Revision #5 narrative (Kitchen redesign)

DATE: May 31, 2023  
PROJECT ARCHITECT: ELEVEN18 ARCHITECTURE, PL  
CONTACT NAME AND NUMBER: Matt Conte, 407-745-5300

**PROJECT NAME:** The Springs of Ballentine  
**PERMIT NUMBER:** N/A  
**PROJECT NUMBER:**  
**FID NUMBER:**

PLEASE NOTE THE FOLLOWING REVISIONS TO THE PROPOSED SET OF DRAWINGS HAVE BEEN COMPLETED  
IN RESPONSE TO REVISED FOOD SERVICE DRAWINGS.

**E207**  
 PARTIAL MECHANICAL POWER PLAN

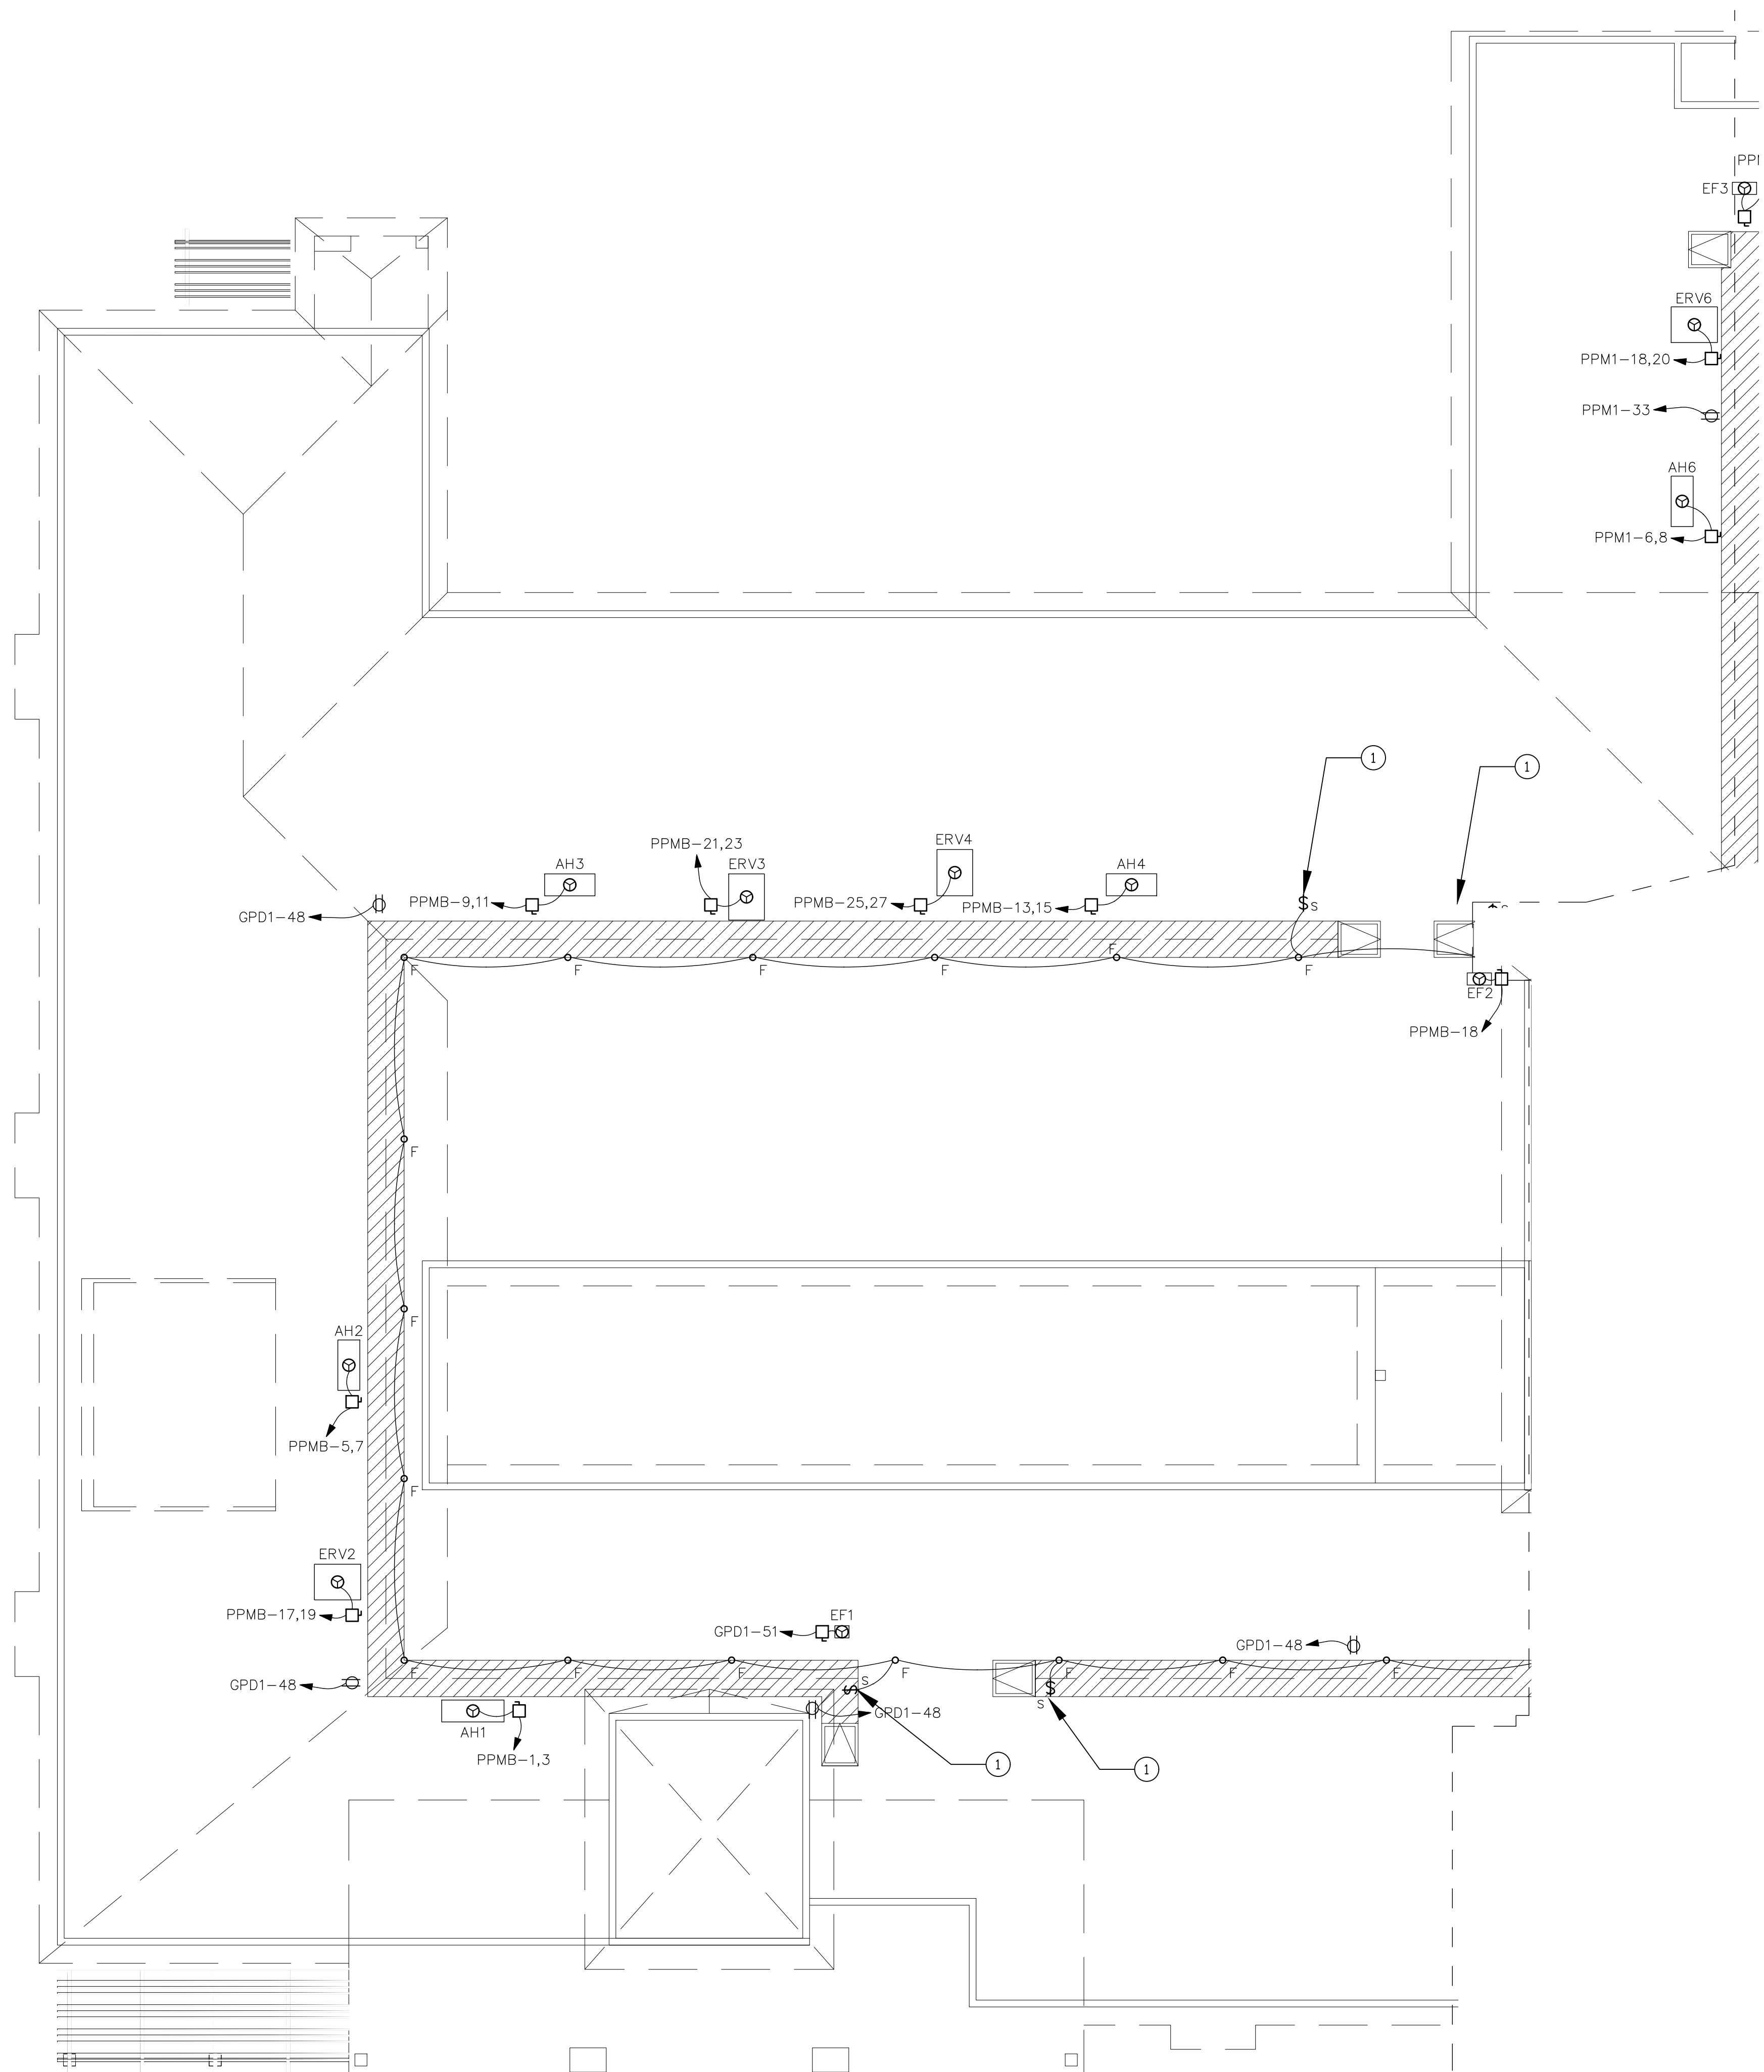
E207

Revised mechanical power plan for kitchen

**E210**  
ENLARGED AREA ELECTRICAL PLAN

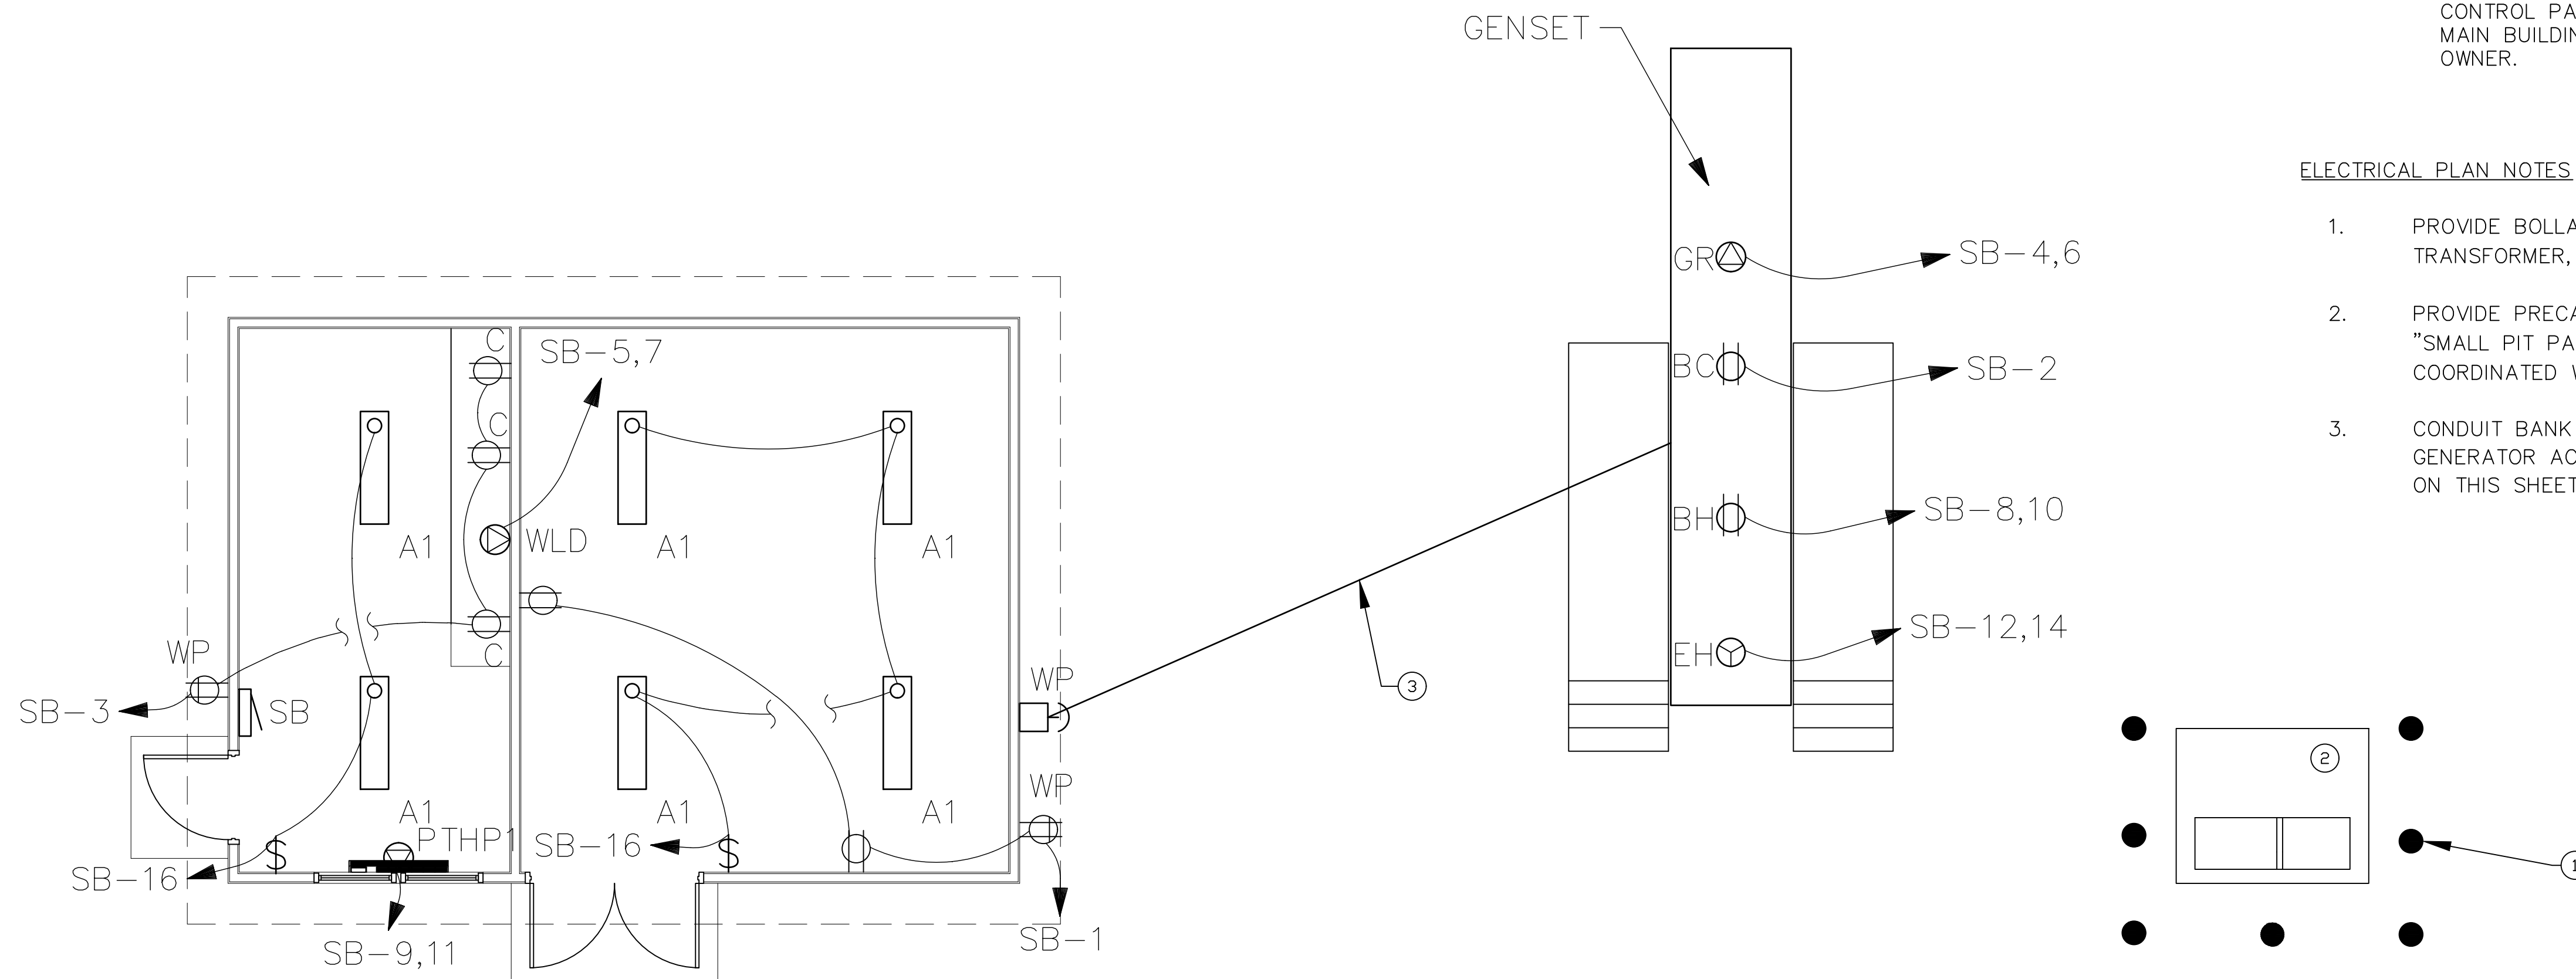
E210

Revised Kitchen/server power plan

**P101**  
PLUMBING COMPOSITE  
PLAN

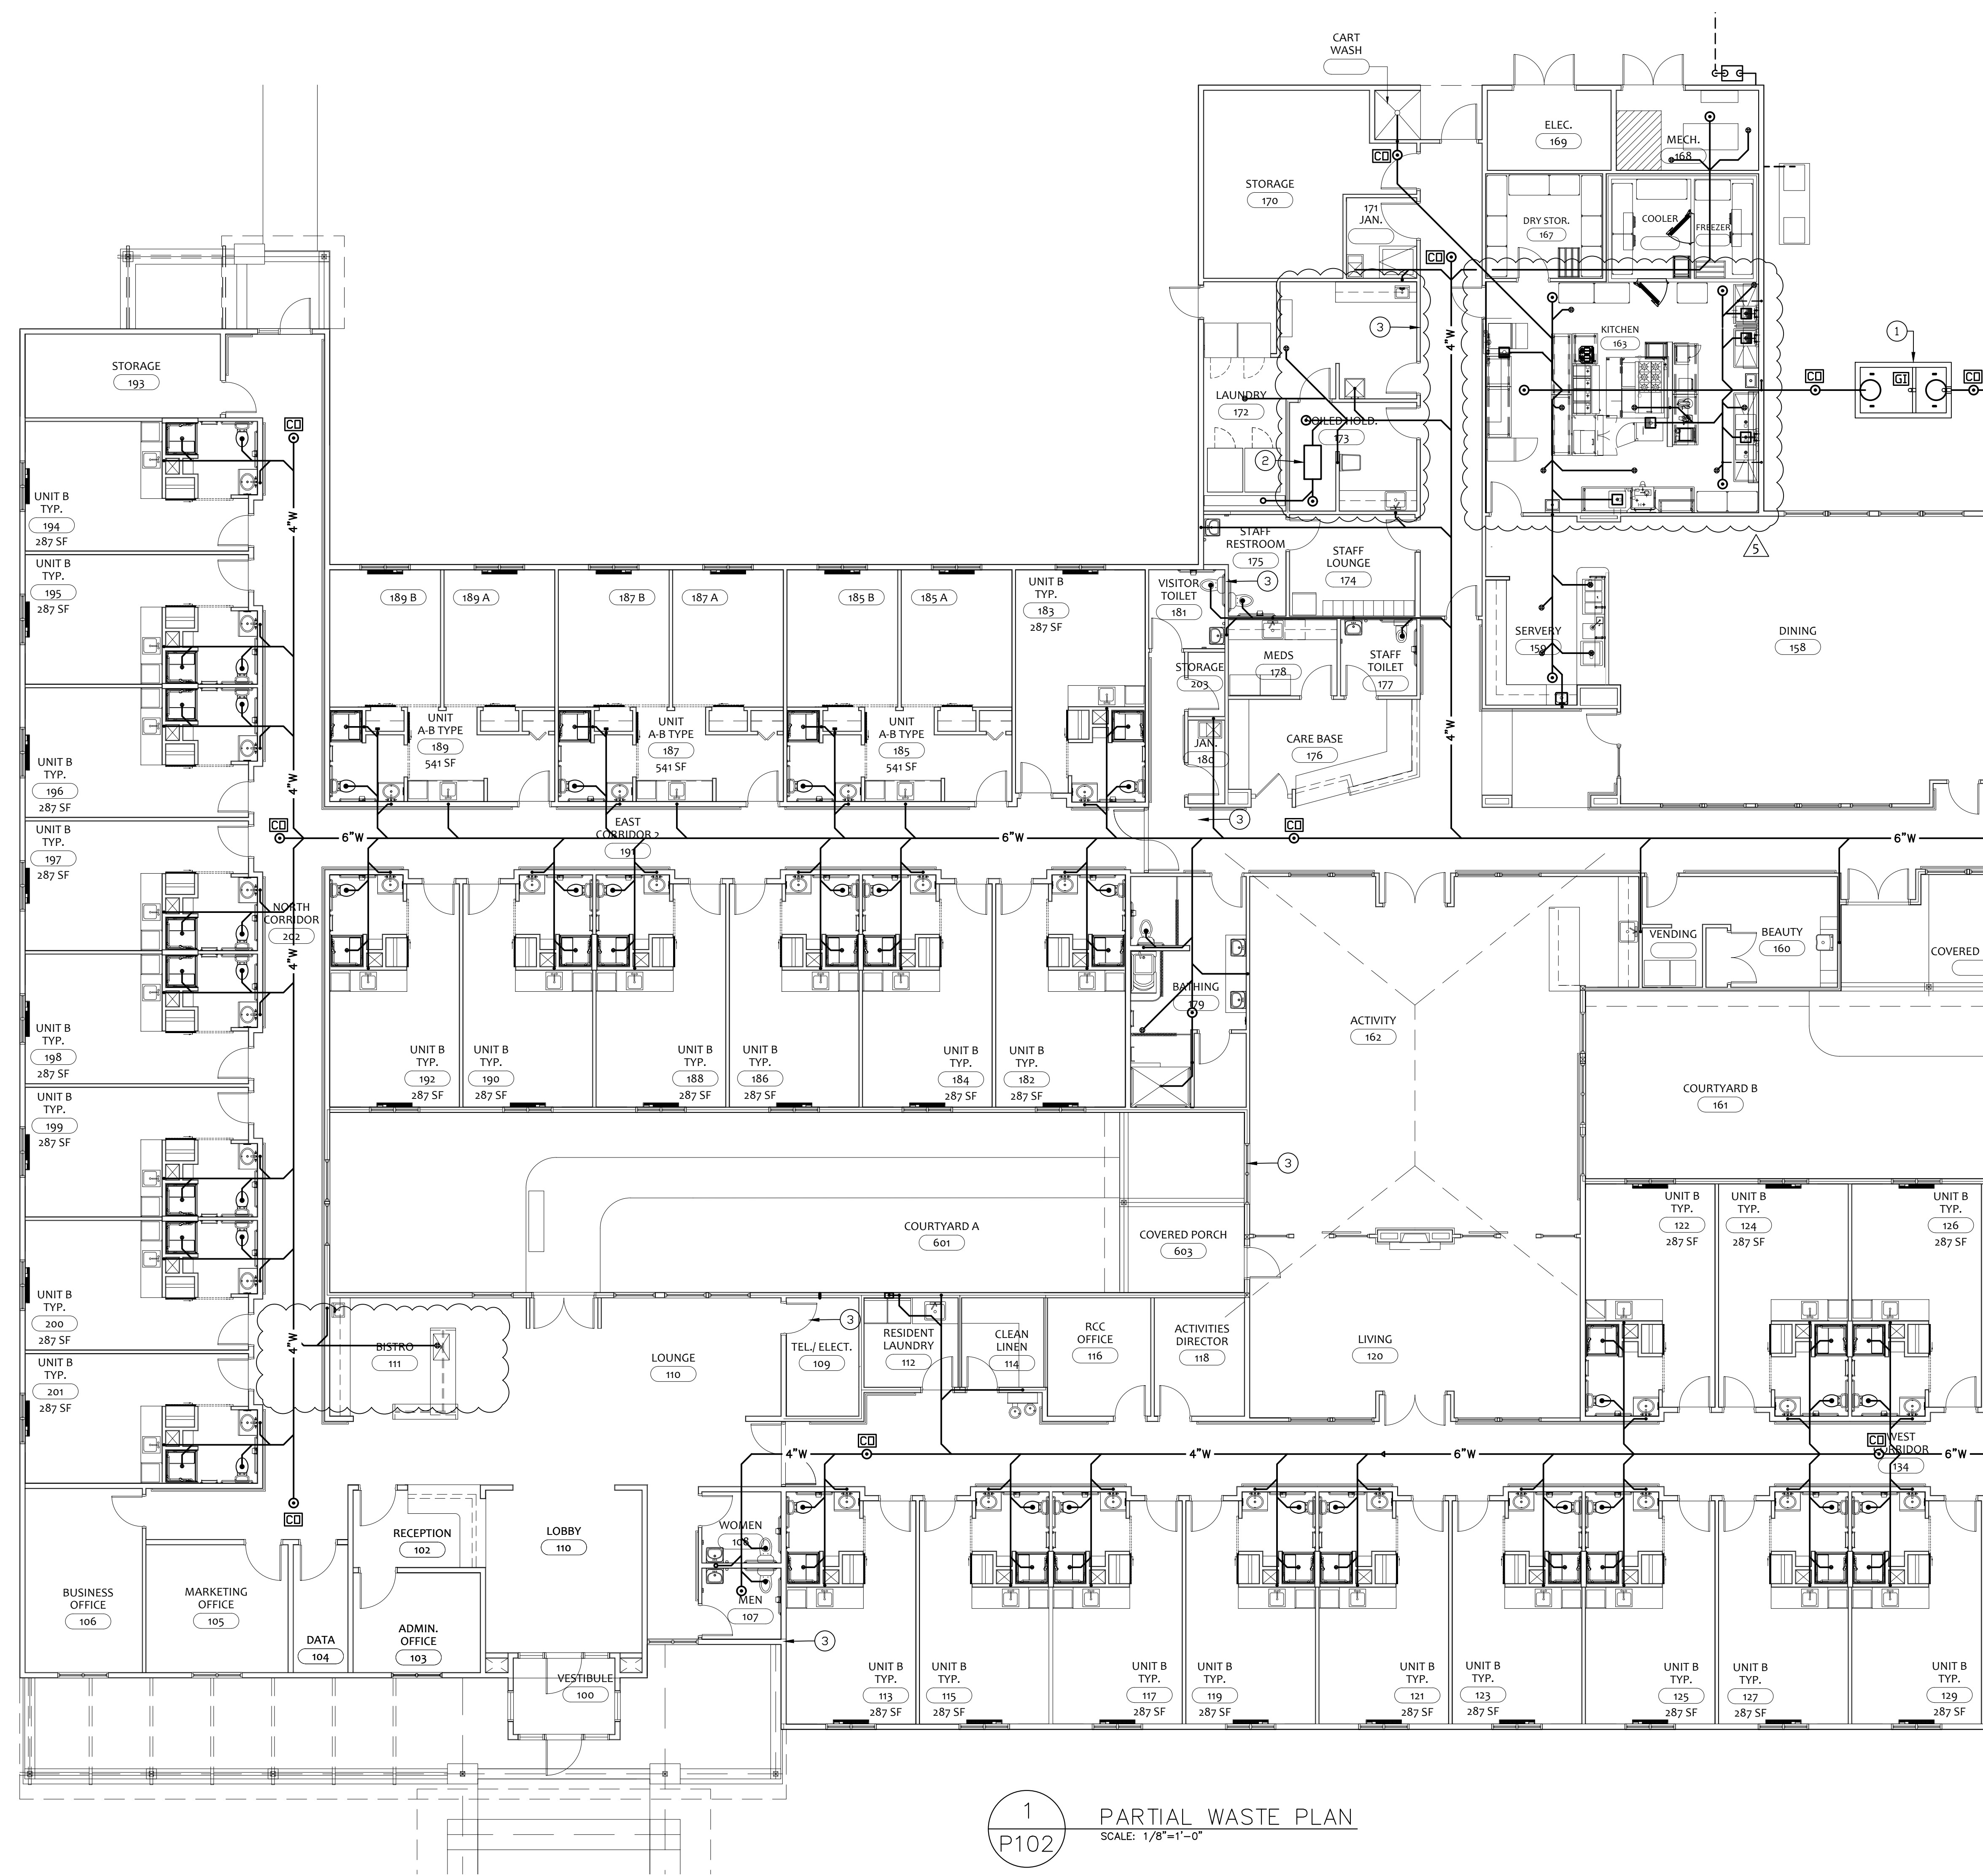
P101

Revised plumbing plan for kitchen
